**Our Ref: EP/144/13/
Your Ref:**

Application for Planning Permission for Works or Extension to a Dwelling

Development Demolish existing conservatory & erect 2 storey side & rear extension. New traditional front porch. Demolish existing garage & construct new carriage house & workshop to the front driveway

Location 91 North Lane East Preston Littlehampton

Block Plan
Garage Proposals
Planning Issue

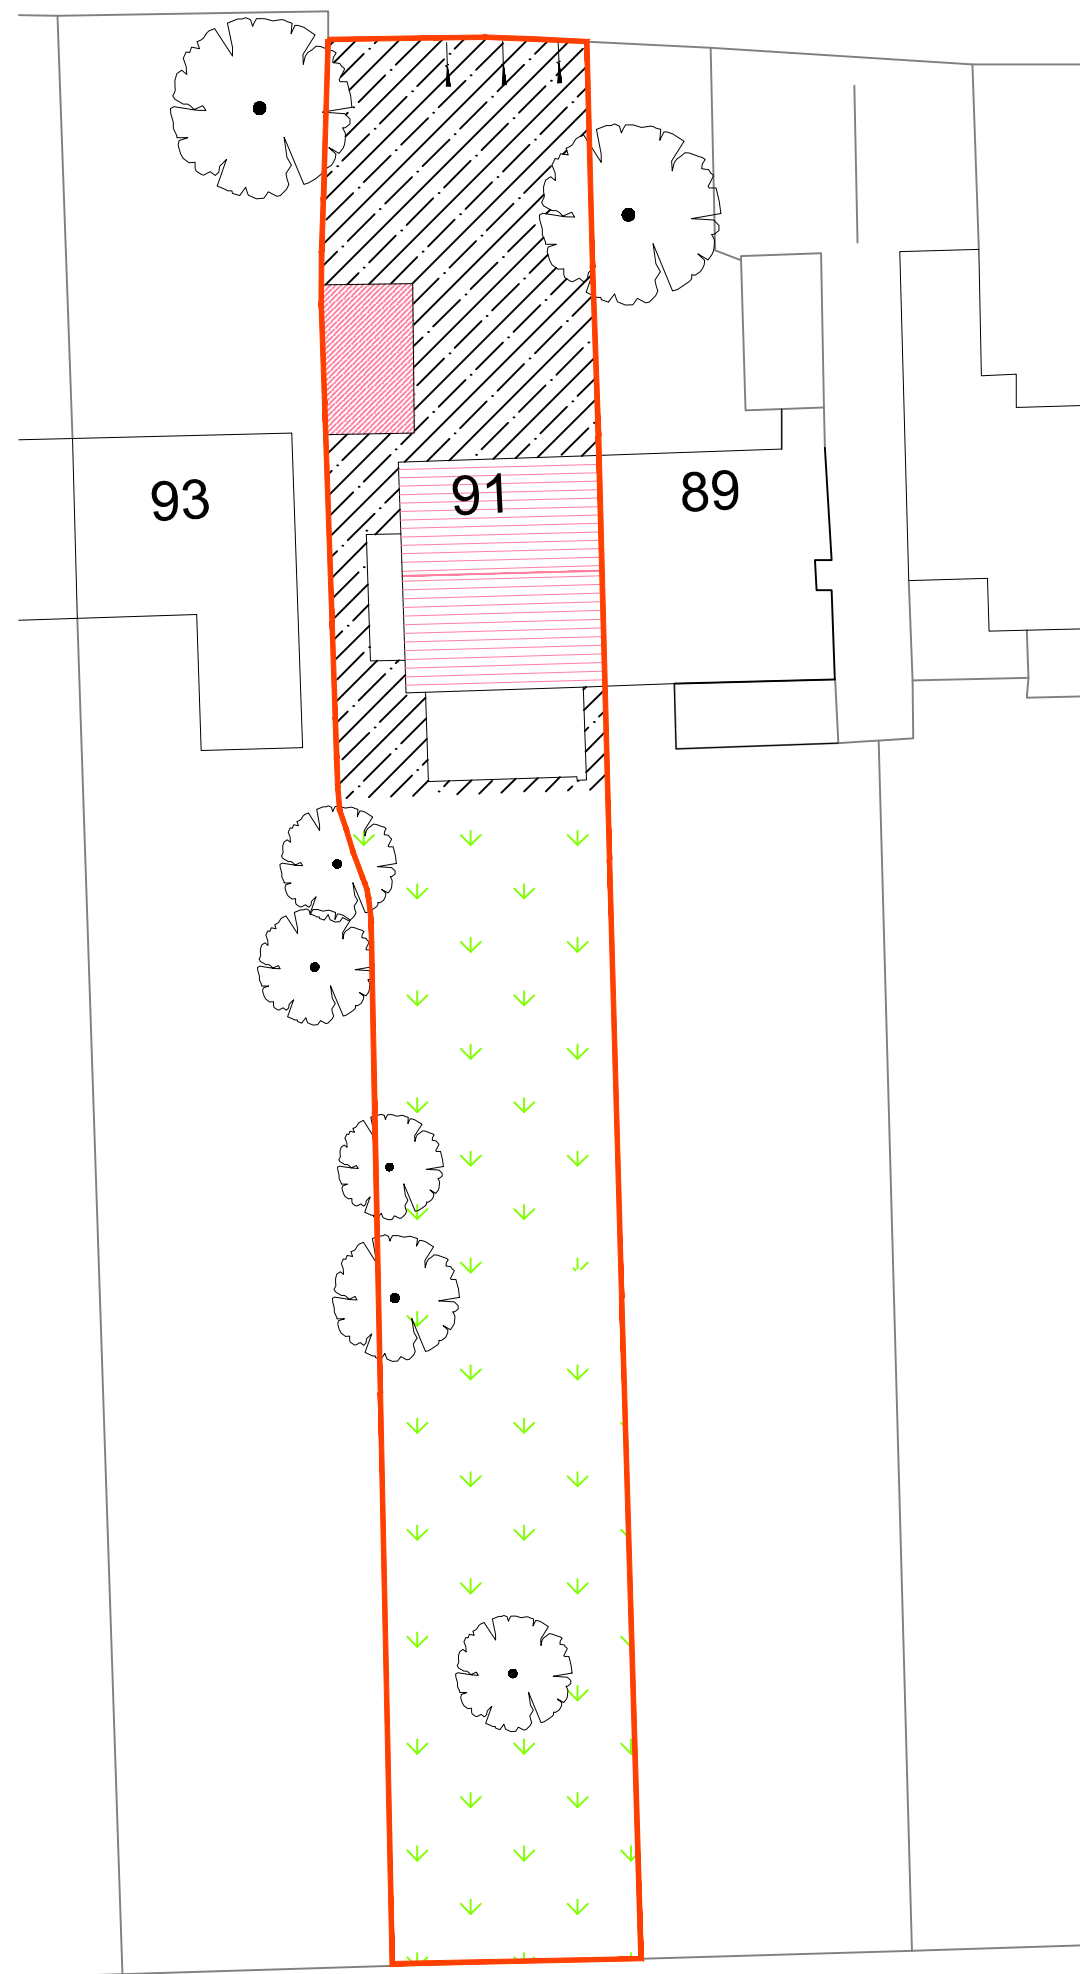
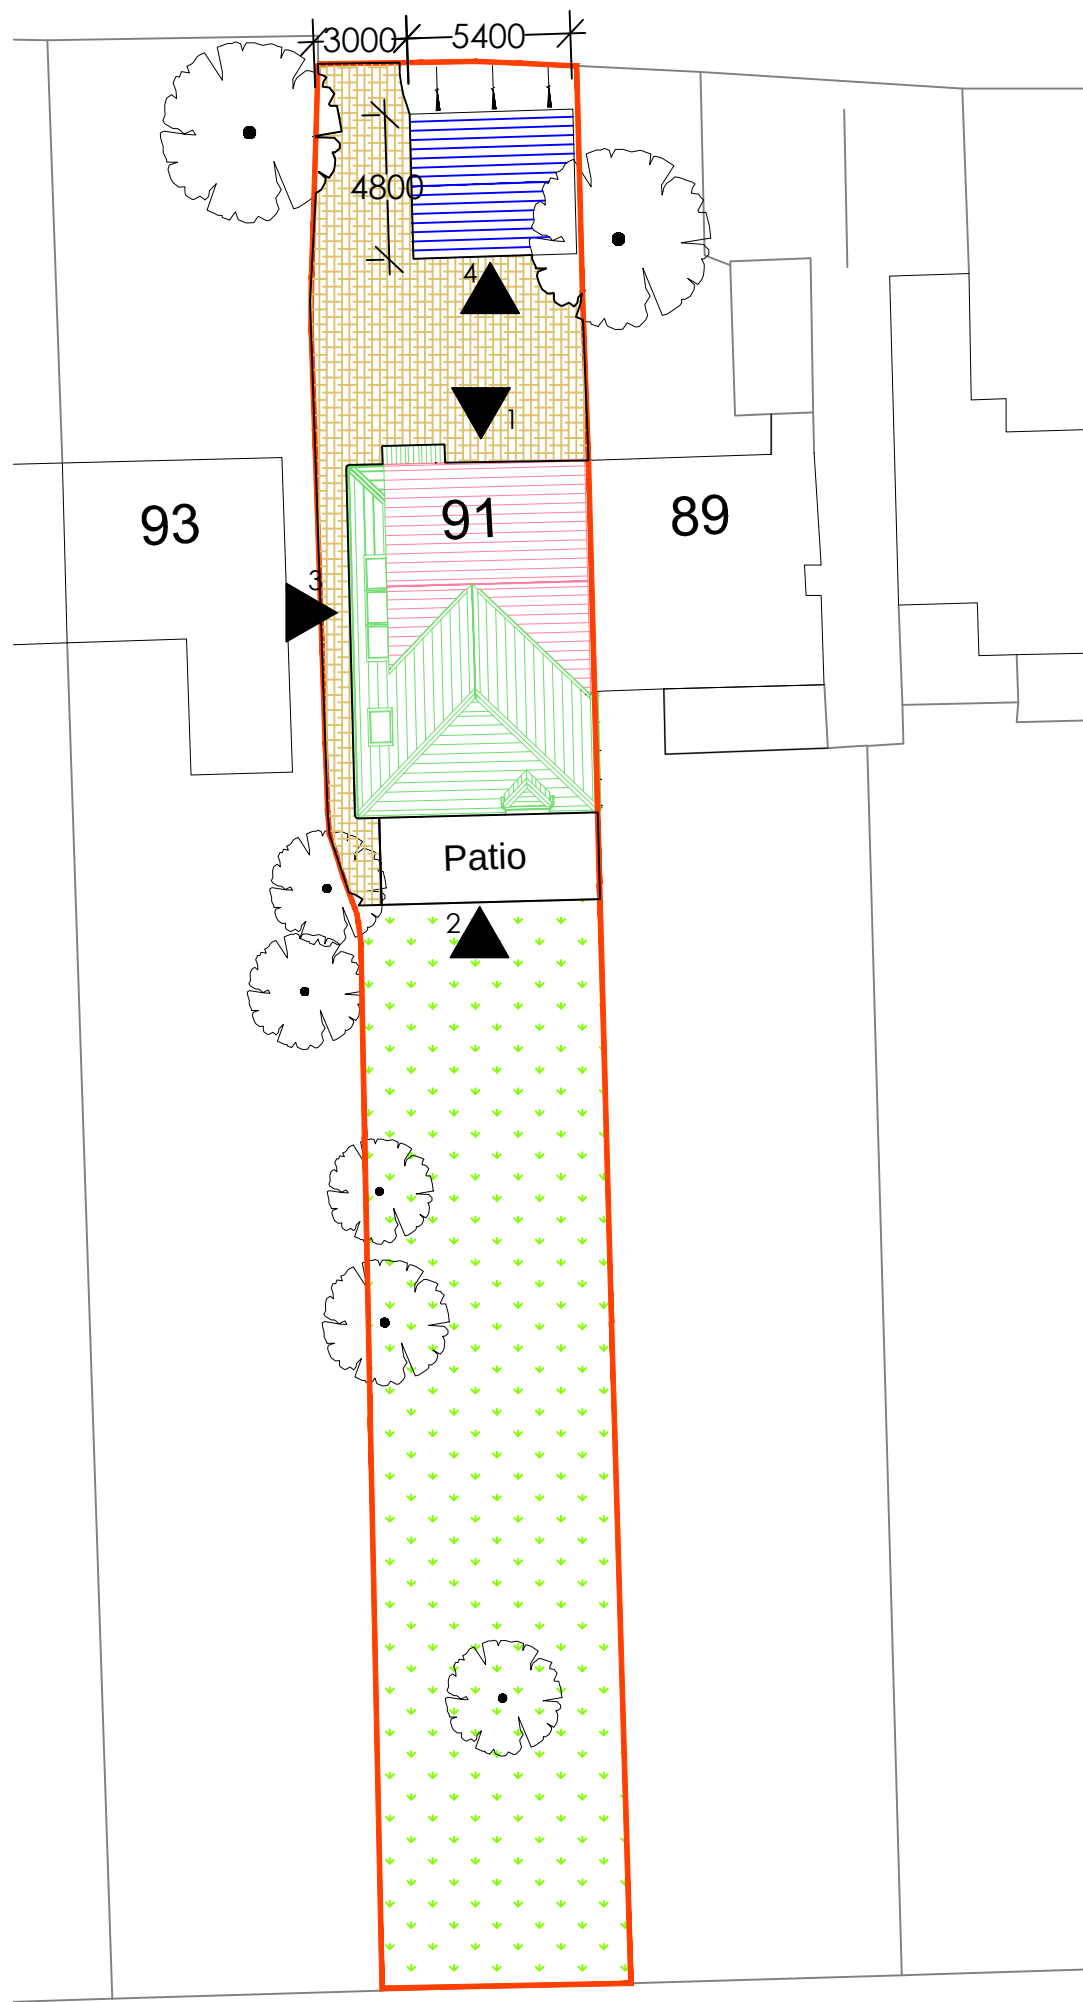
Block Plan

Please submit 1 electronic or 3 paper copies of an amended block/site plan at a scale of 1:500 or 1:200 showing the measurements to each boundary from the proposal. Further details of what must be included on the plan can be found in the National Validation Requirements.
